Recommendation Report for Planning Permission for Works or Extension to a Dwelling

REF NO: AW/358/21/HH

LOCATION: 16 Wilman Gardens
Aldwick
PO21 4BP

PROPOSAL: Loft conversion to form new first floor (resubmission following AW/277/21/HH).

Proposed

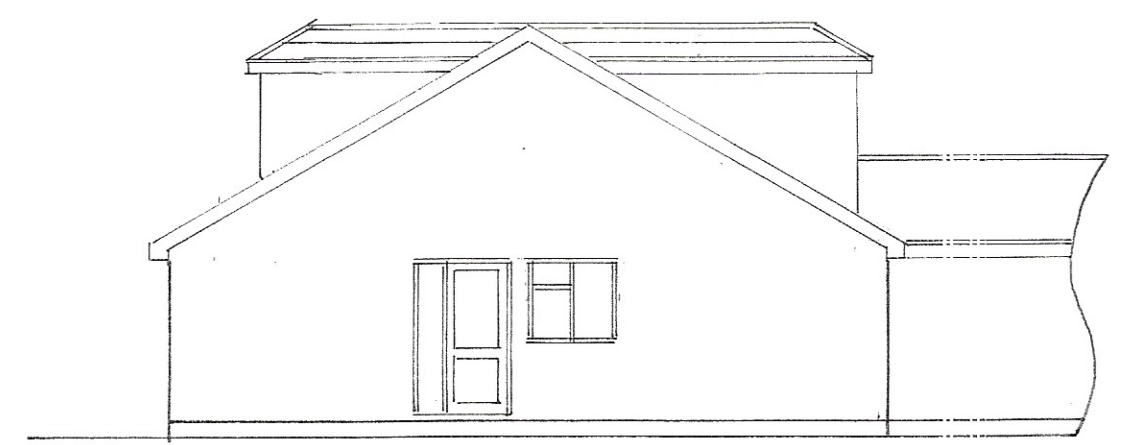
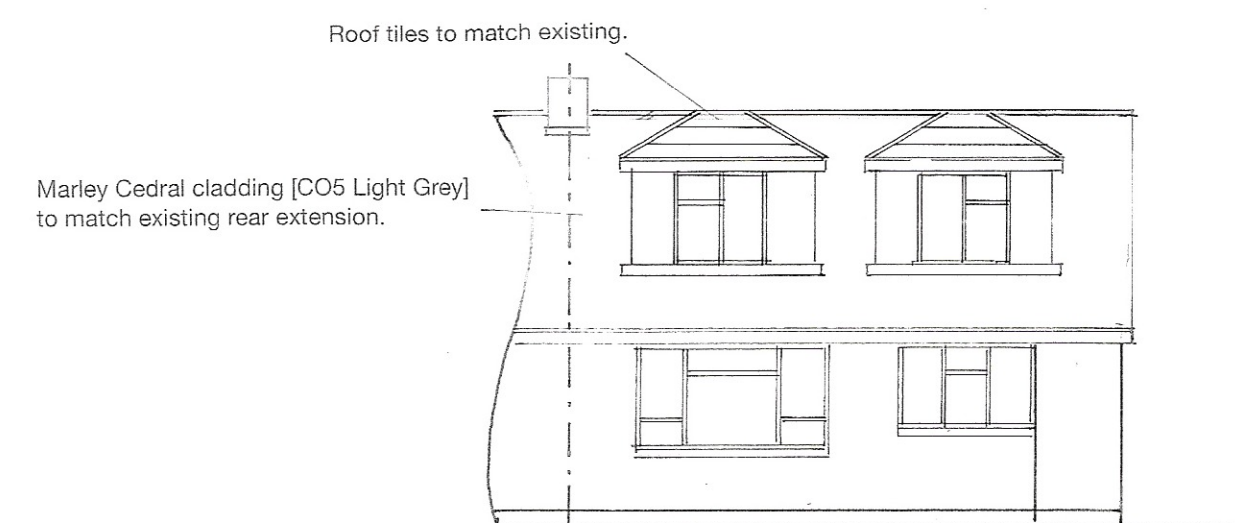
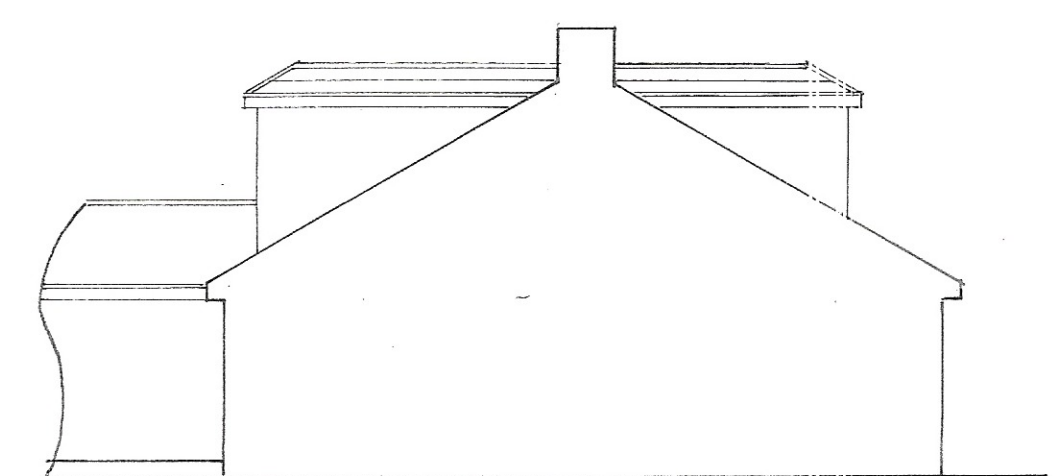
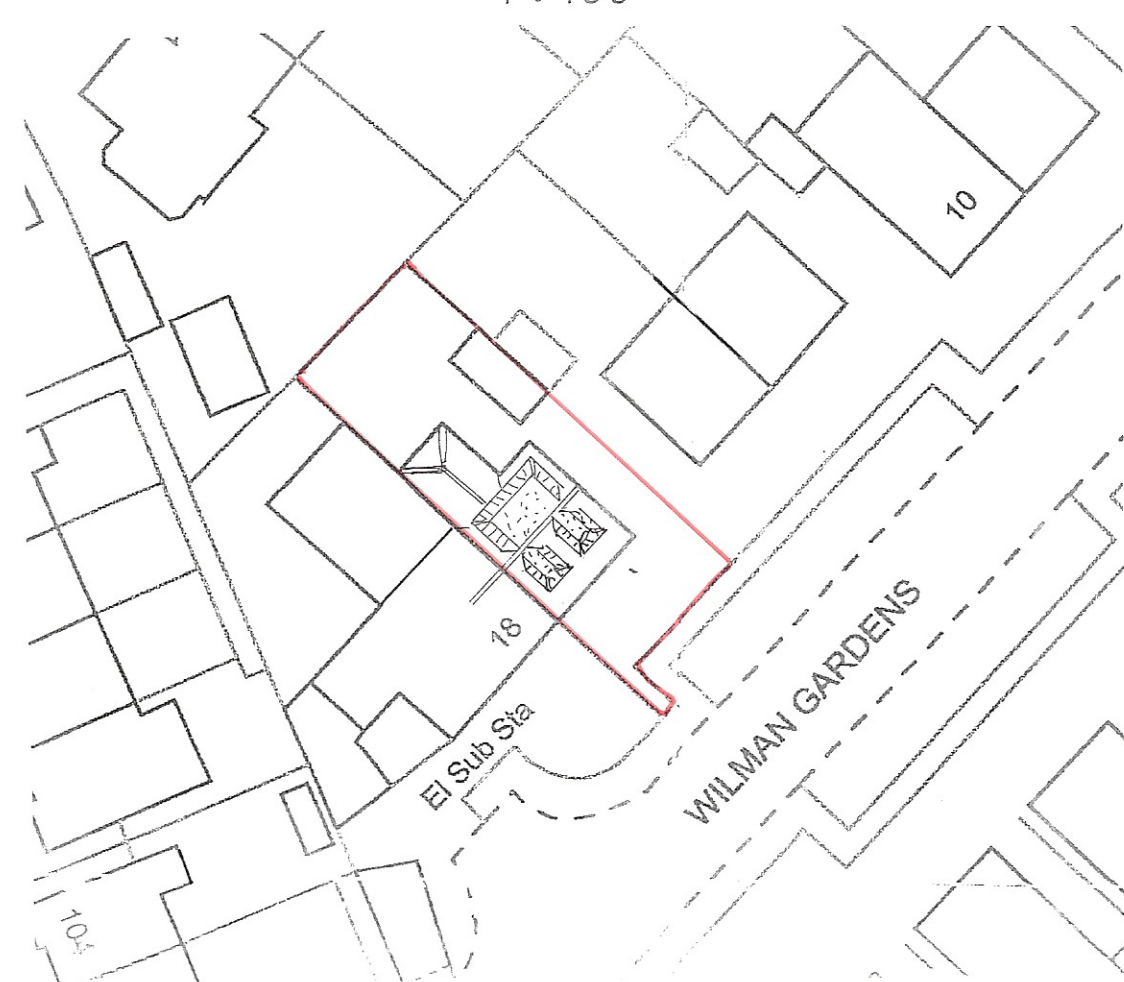
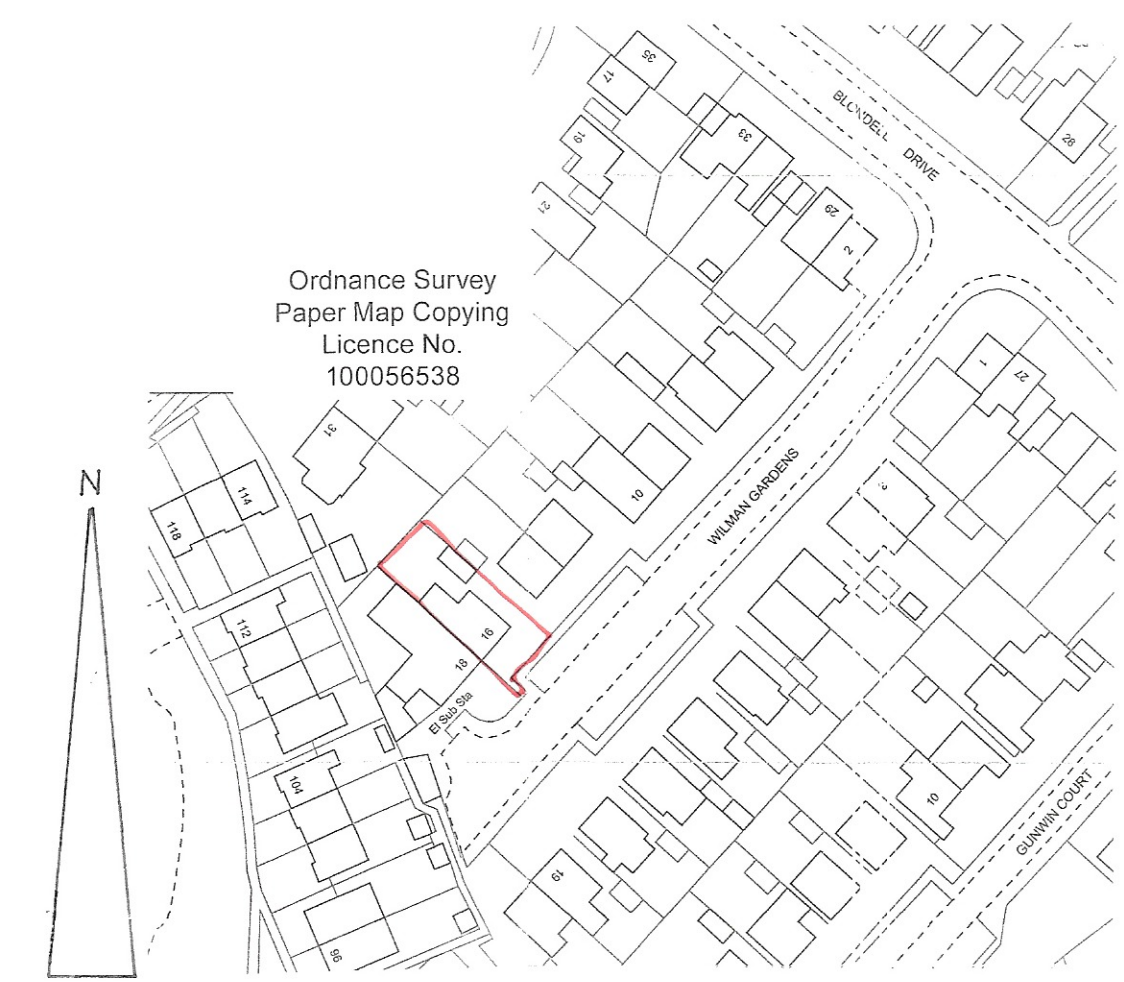
The application seeks two dormers to the front elevation. These will have a hipped roof and with their size fairly modest they do not appear overly dominant on the roof slope retaining around 0.7m to the eaves. The design has been altered from a previous application and now appears better integrated with the property and appropriate in design and scale.

The 2nd proposed dormer, located to the rear is less visible and acceptable in appearance on the street scene. A dormer to this elevation is also likely allowed under permitted development.

Cedral Light Grey cladding is proposed to the external elevation of the dormers. There are examples of cladding within the street scene and the proposed material would be acceptable.

The front elevation introduces 2 individual dormers with a height of 2.15m, depth of 3.1m and length of 2.5m. The rear elevation will have 1 larger dormer with a height of 2.45m, depth of 4m and length of 6.15m.

The rear facing dormer will have 2 windows serving a bathroom and a bedroom. Whilst these will introduce views that are not currently available, with 13m retained to the rear boundary, it is not considered views will be significant. A dormer could also be constructed to the rear under permitted development which would introduce views similar to that proposed.

proposed roof plan

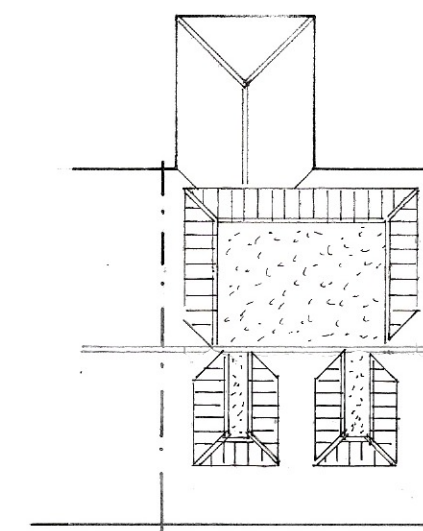
Due to its siting of the dormers, contained in the existing footprint of the property, they are not considered to result in demonstrably adverse overbearing or overshadowing upon neighbouring properties.
